CITY OF ALBUQUERQUE

**RE: Estates at Glendale Unit 2 - 7900 Glendale (File: B19D027)
Pad Certification for plat lots 2, 3, and 4 (Lots 10, 11, and 12 per G&D)
Grading and Drainage Plan, Engineer's Stamp Date 4-29-16
Certification dated 9-29-2016**

SECTION C-C  
NTS

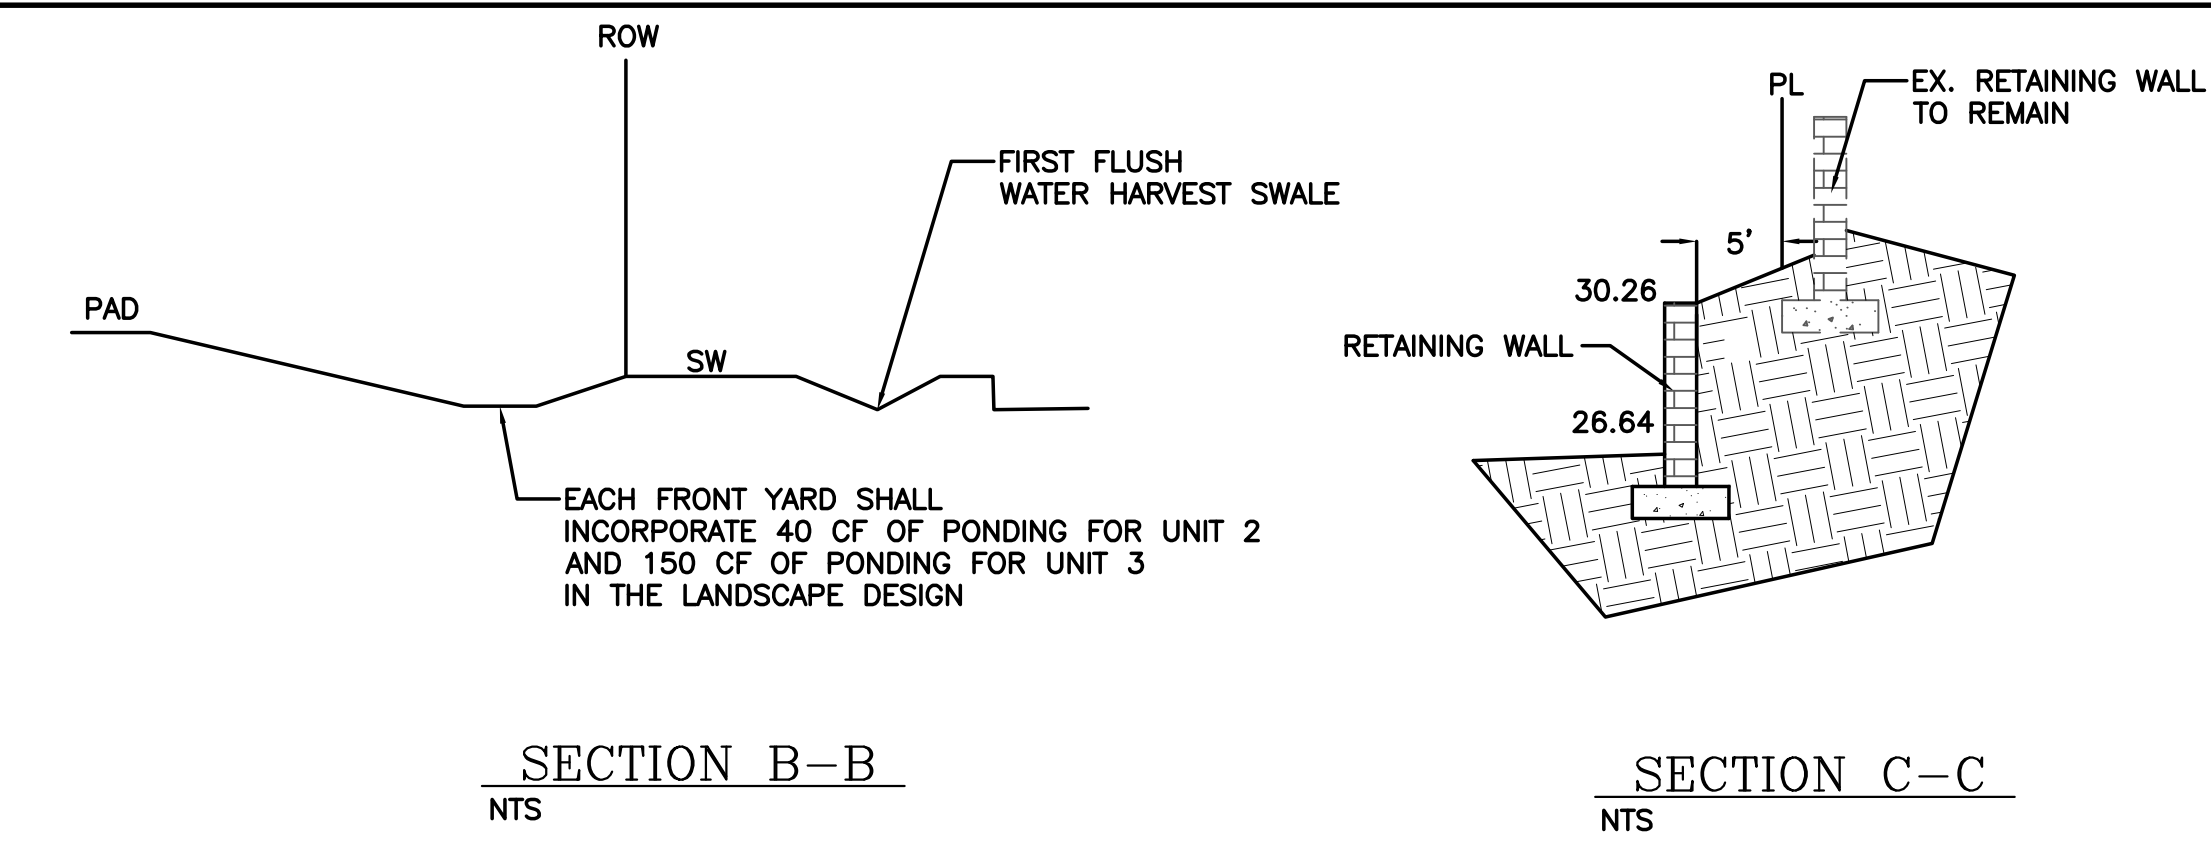
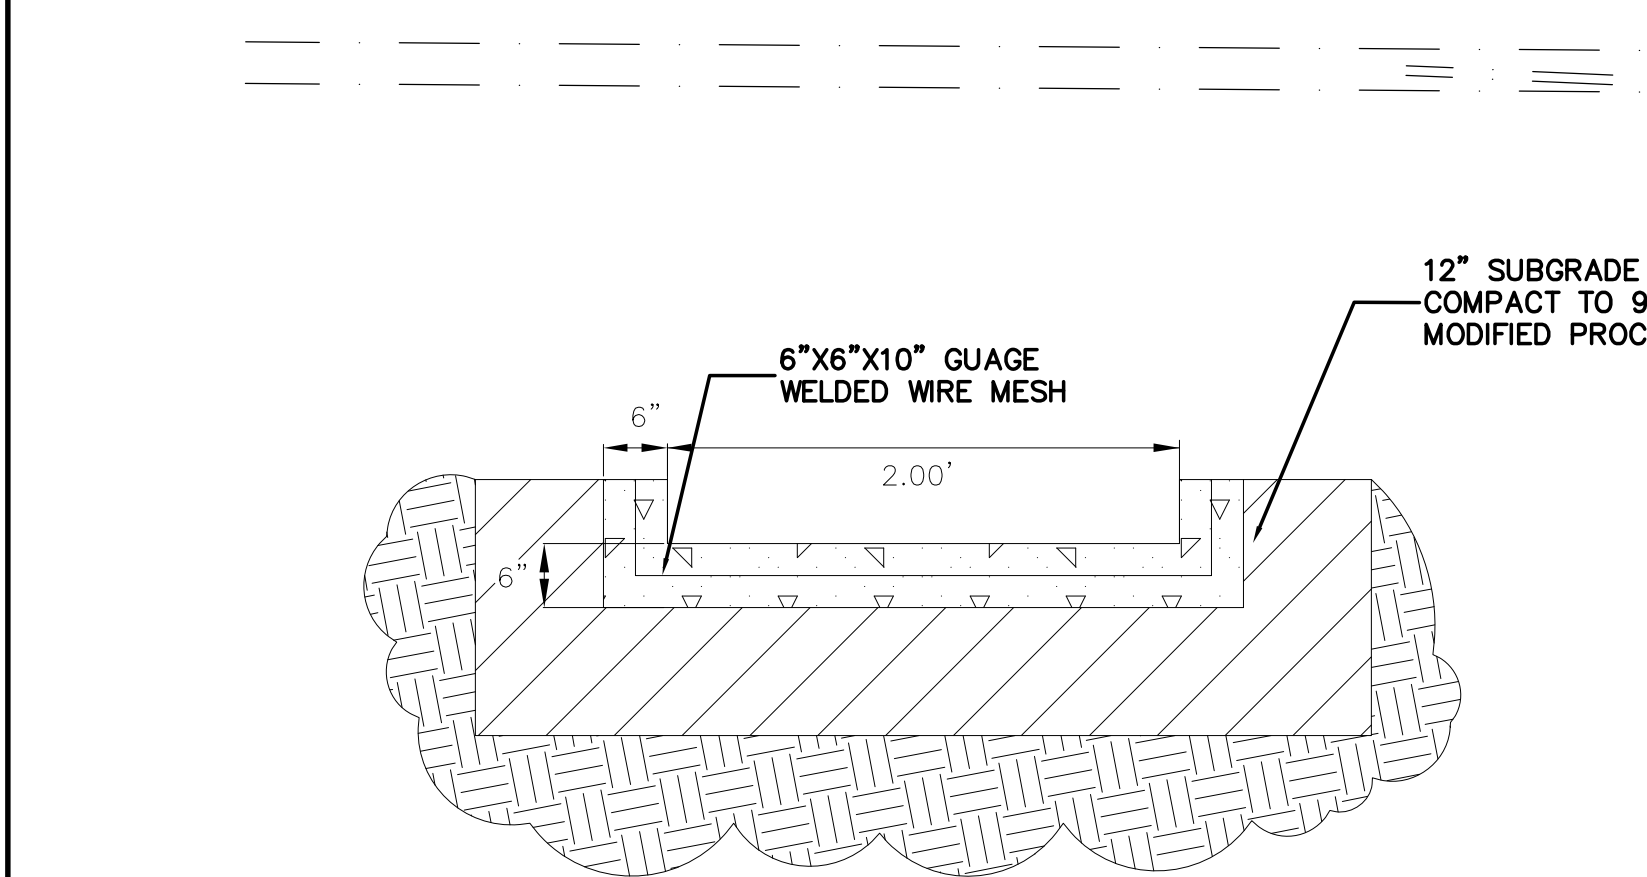
Prior to Pad Certification for Lot 1 (Lot 9 per G&D) , the double retaining wall must be built with the opening in the wall to discharge to the SW Culvert per Section C-C of Grading Plan. Rip-rap to culvert must also be in place.

ENGINEER'S SEAL  4/28/18 DAVID SOULE P.E. #14522	ESTATES AT GLENDALE UNIT 3	DRAWN BY: WCUJ DATE: 1-18-17 21425-LAYOUT-1-25-18
	GRADING AND DRAINAGE PLAN	SHEET # 3
	 Rio Grande Engineering 1606 CENTRAL AVENUE SE SUITE 201 ALBUQUERQUE, NM 87106 (505) 872-0999	JOB # 21425

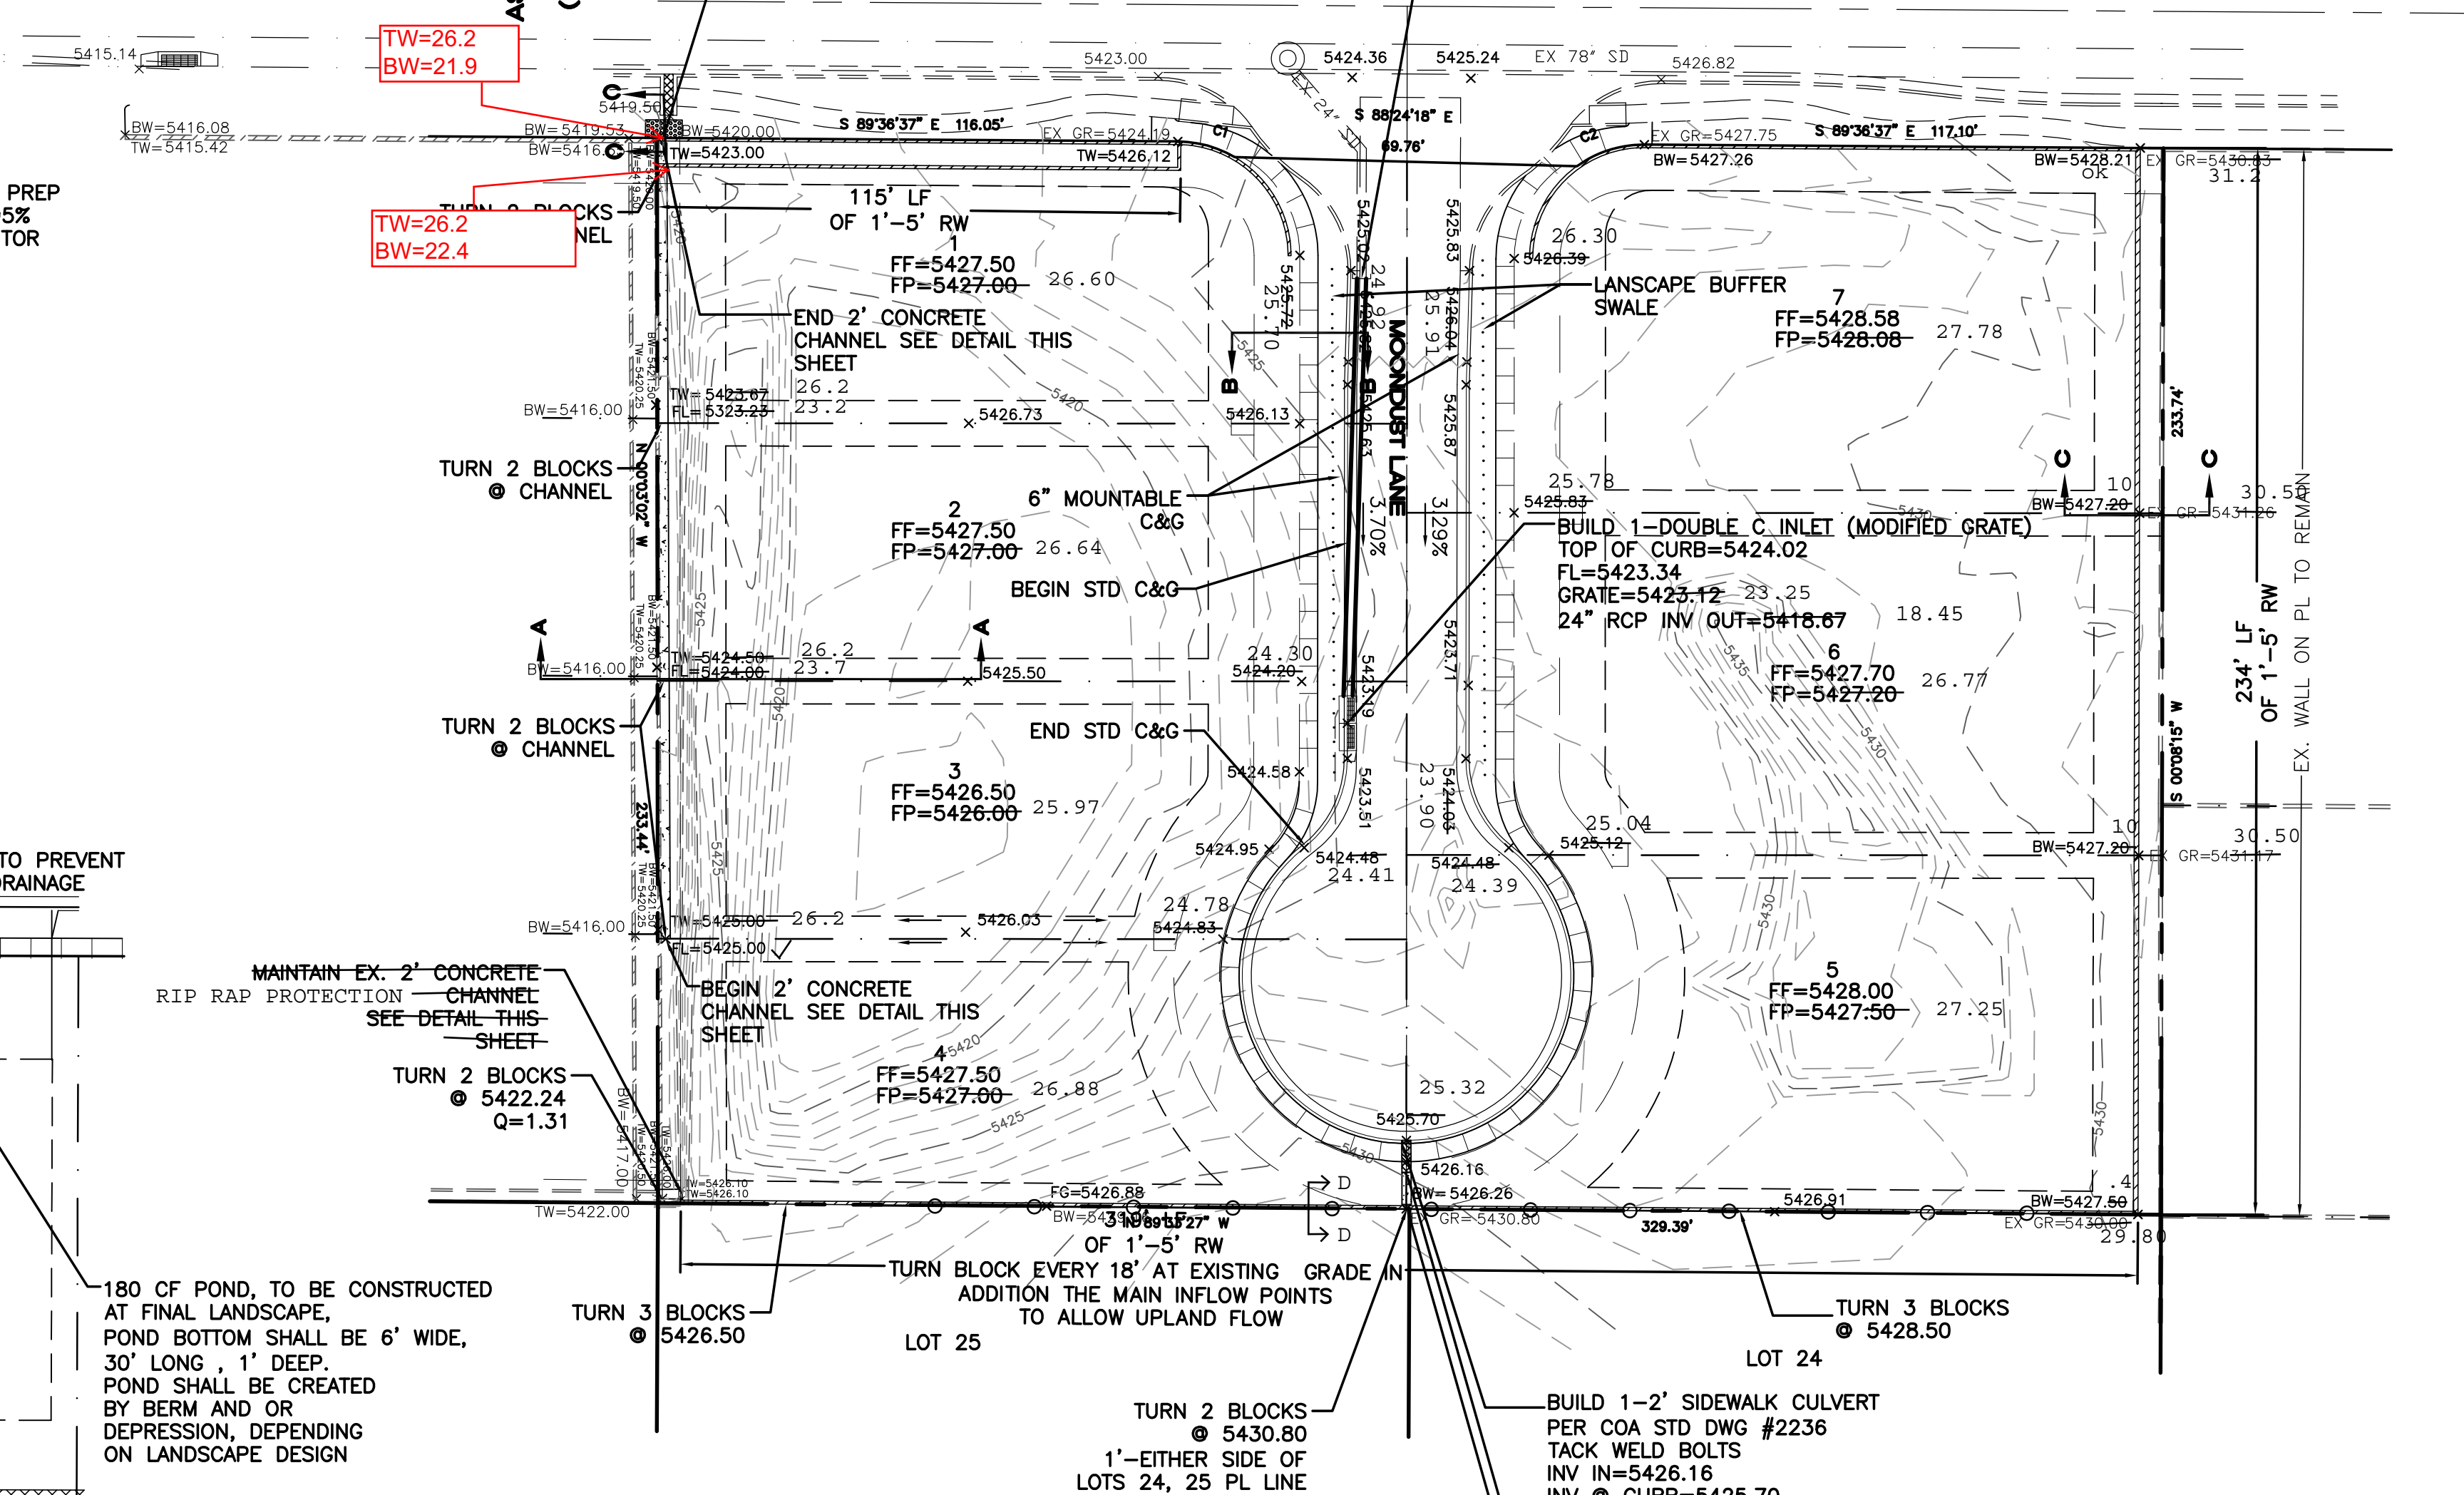
The Bottom of wall elevations at the rear of Lots 6 and 7 (14, 15) were raised on the Glendale Unit 3 grading plan and approved per that plan. The Engineers Certified plan for these lots need to reflect the this change. Provide gutters to direct roof drainage to the front of these lots, since there is little to no slope across the rear yards.
